Re: Palomas Apartments
8320 Palomas Ave. NE
Traffic Circulation Layout
Architect's Stamp 12-23-2021 (D19-D032)

Based upon the information provided in your submittal received 02-11-2022, the above referenced plan cannot be approved for Building Permit until the following comments are addressed:

AS-1.0

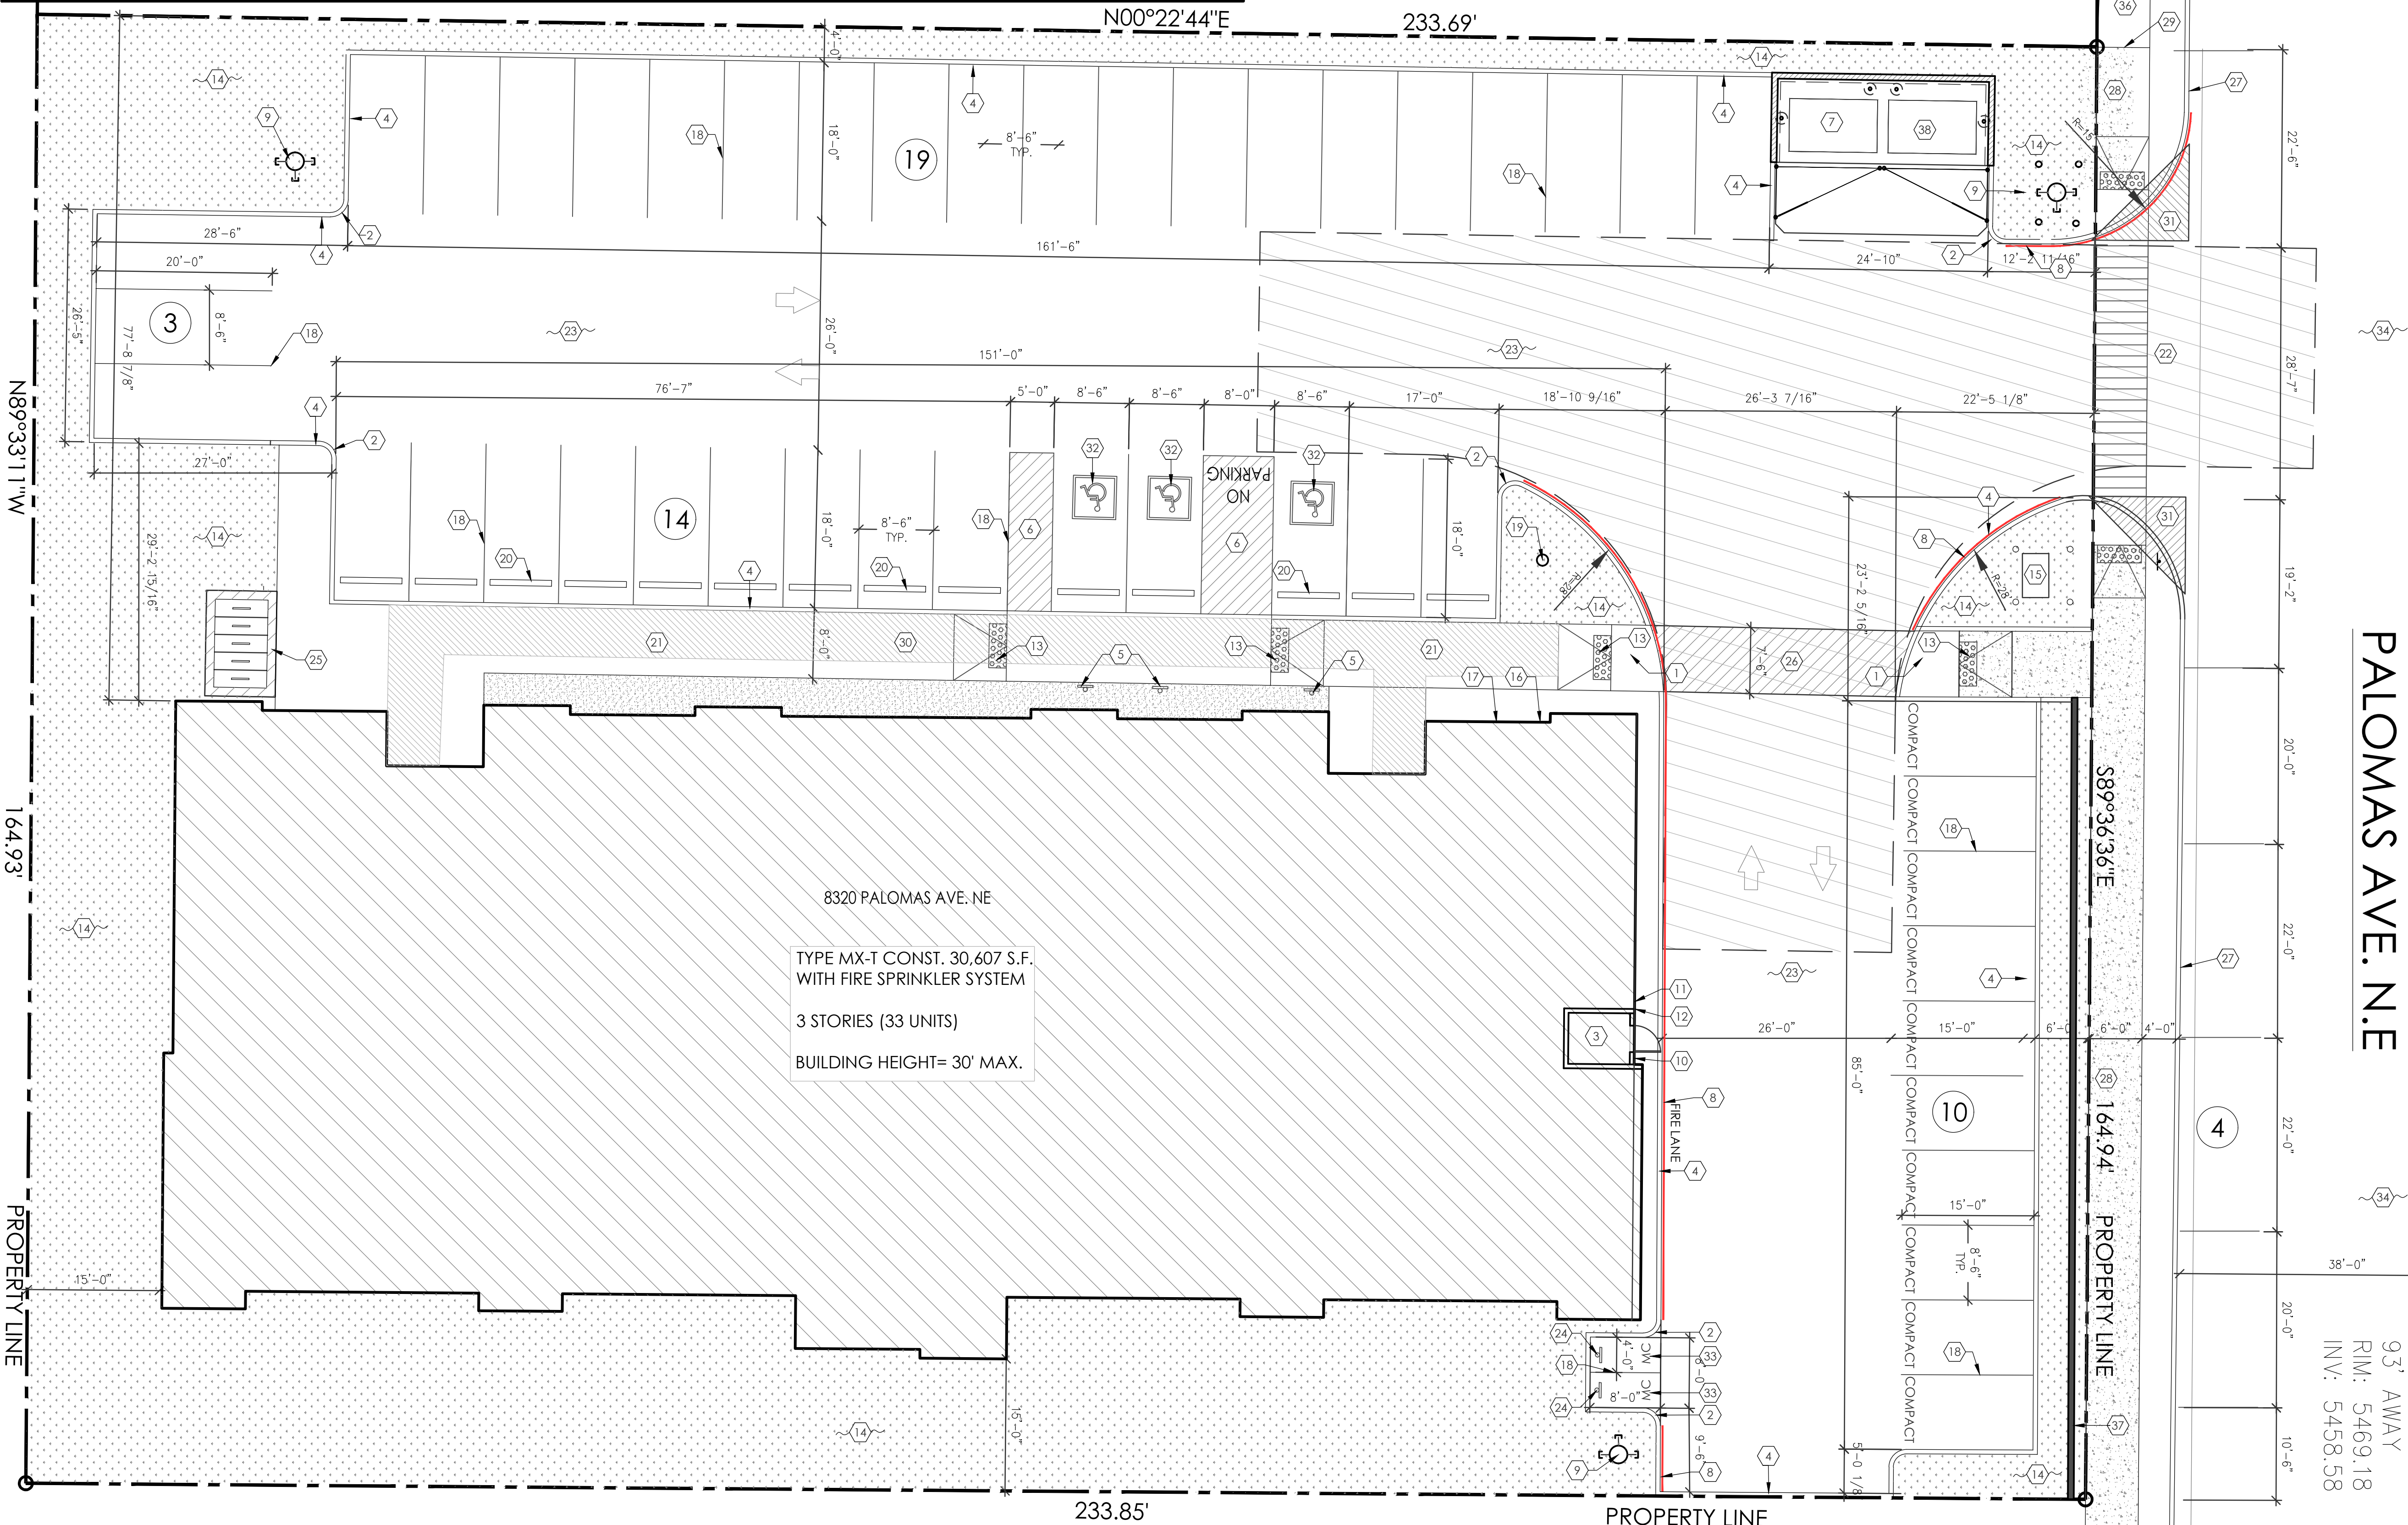
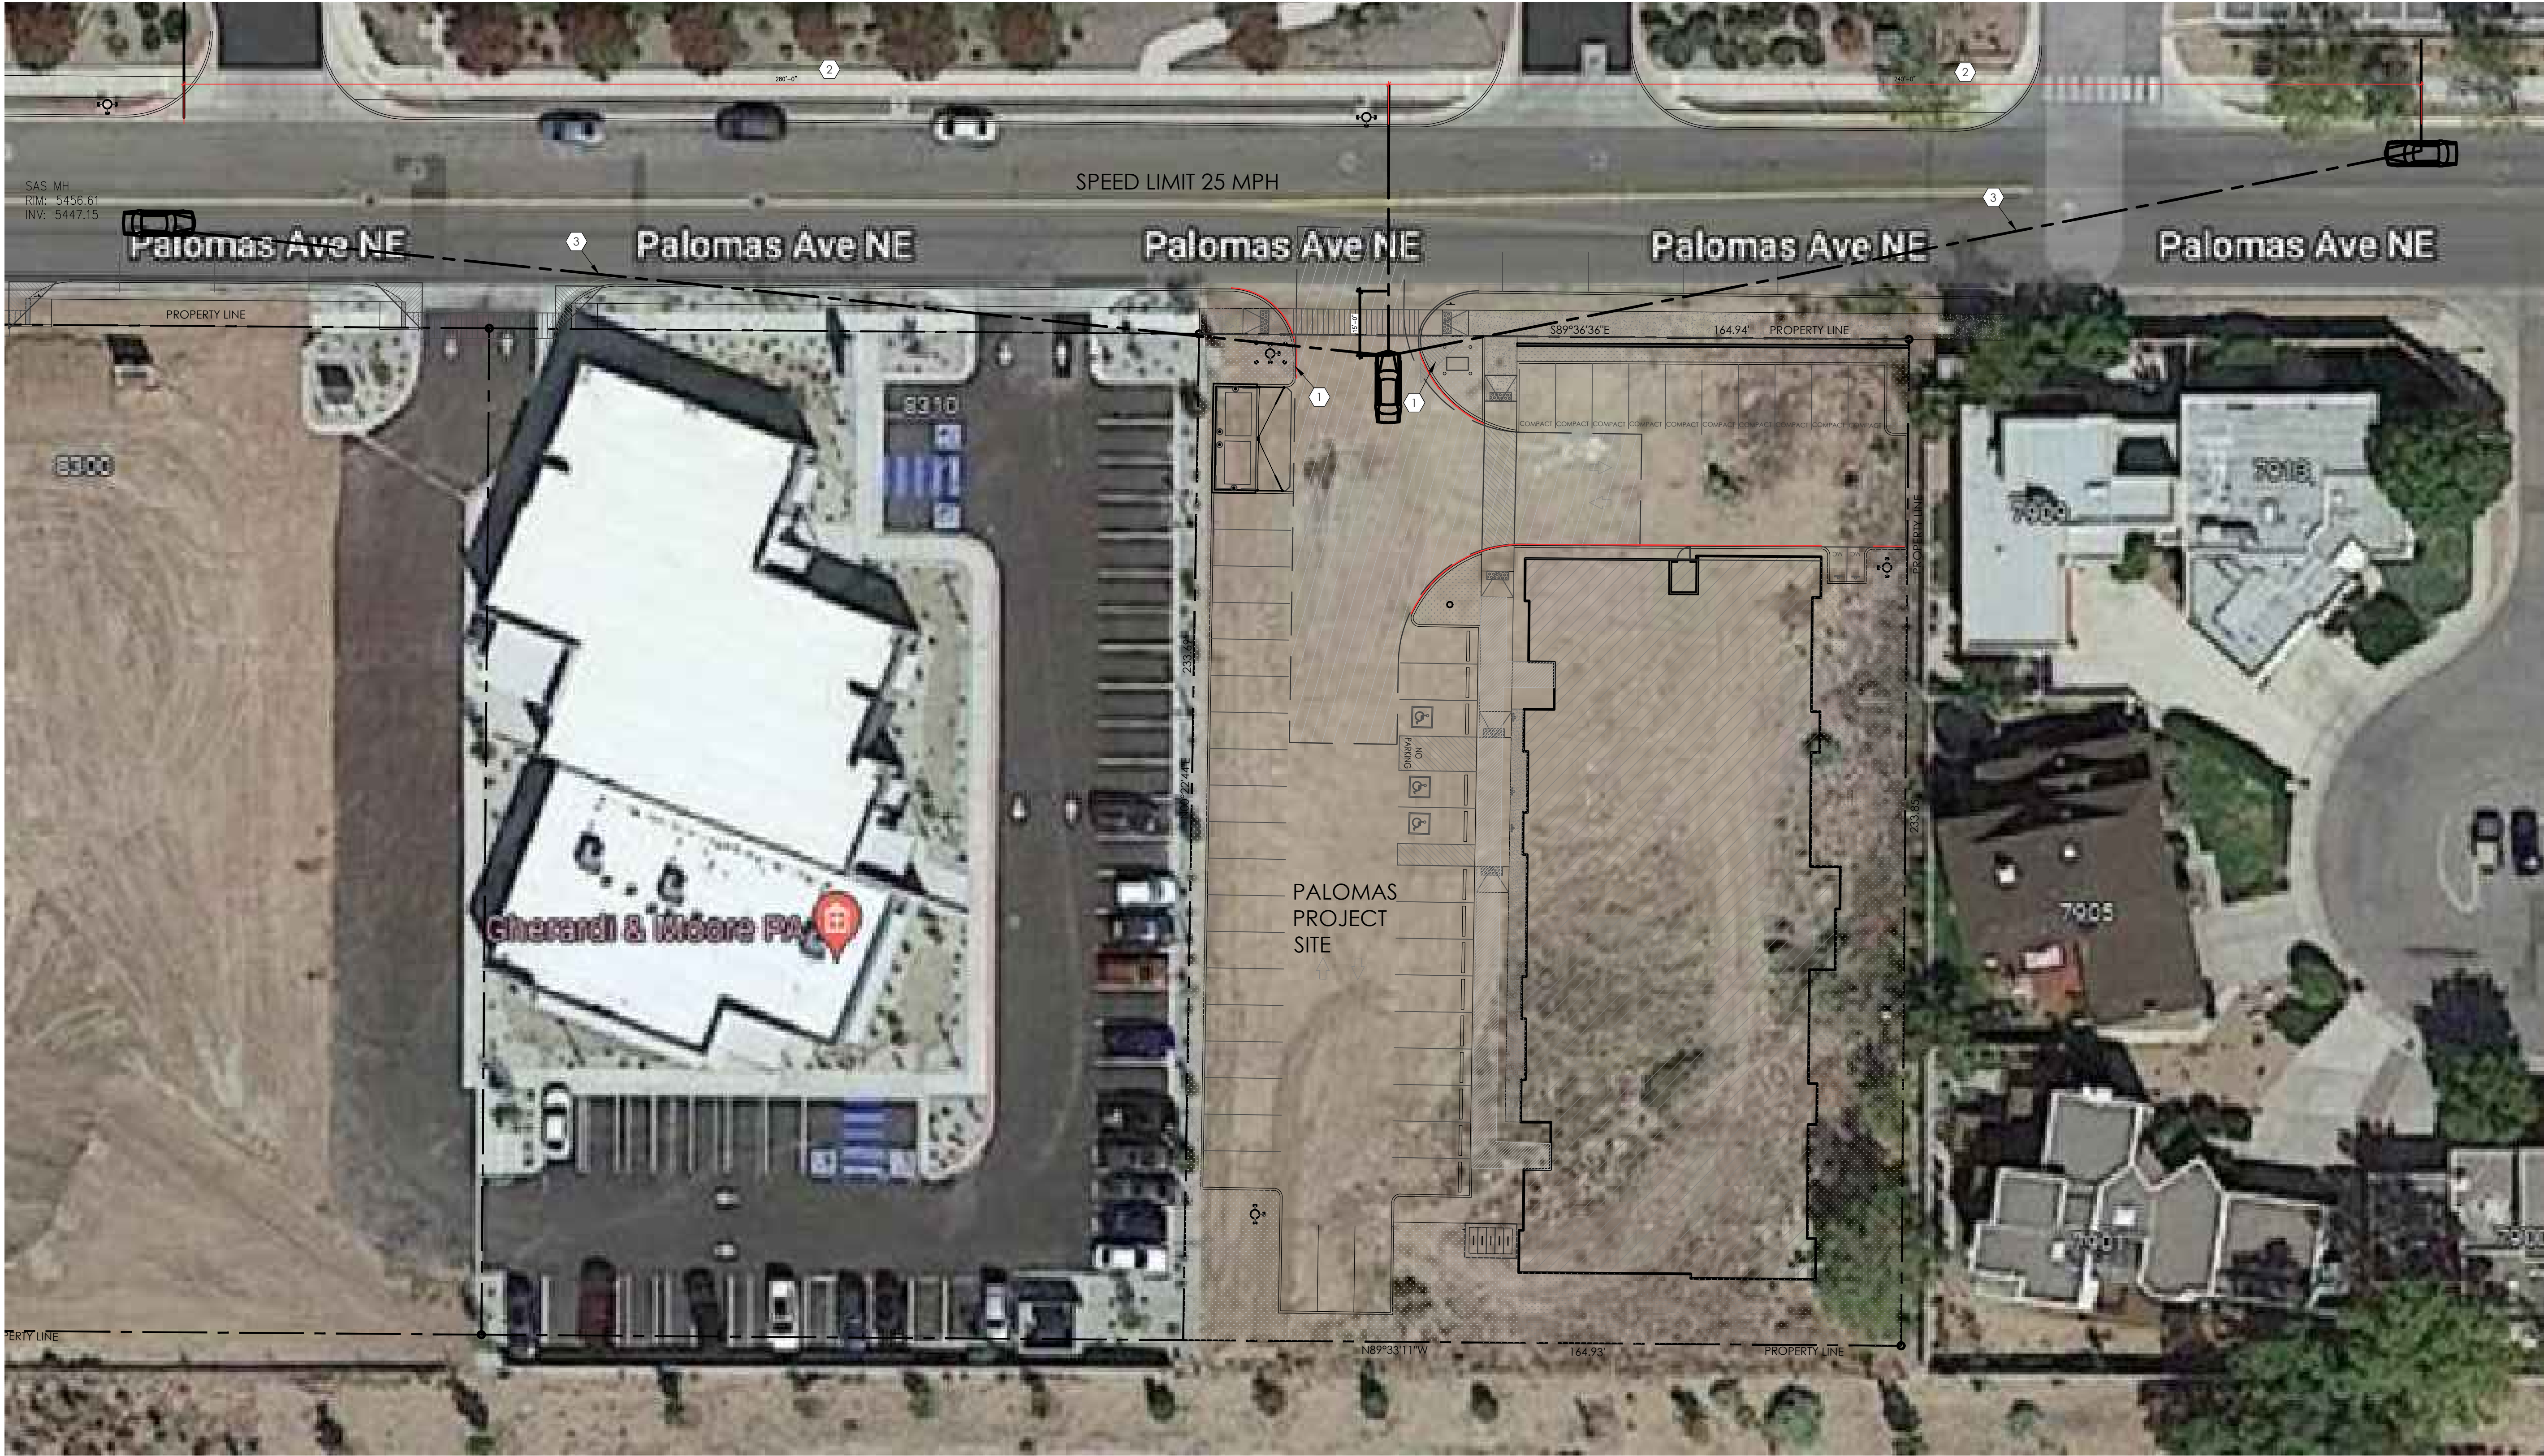
1. Please revise ADA ramp details. Cross slope should be 2%max.
2. Construction new drivepad per COA std dwg 2426. Please add a note (Parallel Ramp option).
3. Key note 30 is missing.
4. Provide a copy of Fire Marshal and Solid Waste Approval.
5. **Keyed Note 29:** Explain why are you using COA std Dwg 2432?
6. A sidewalk easement will be needed for sidewalk located outside of public ROW
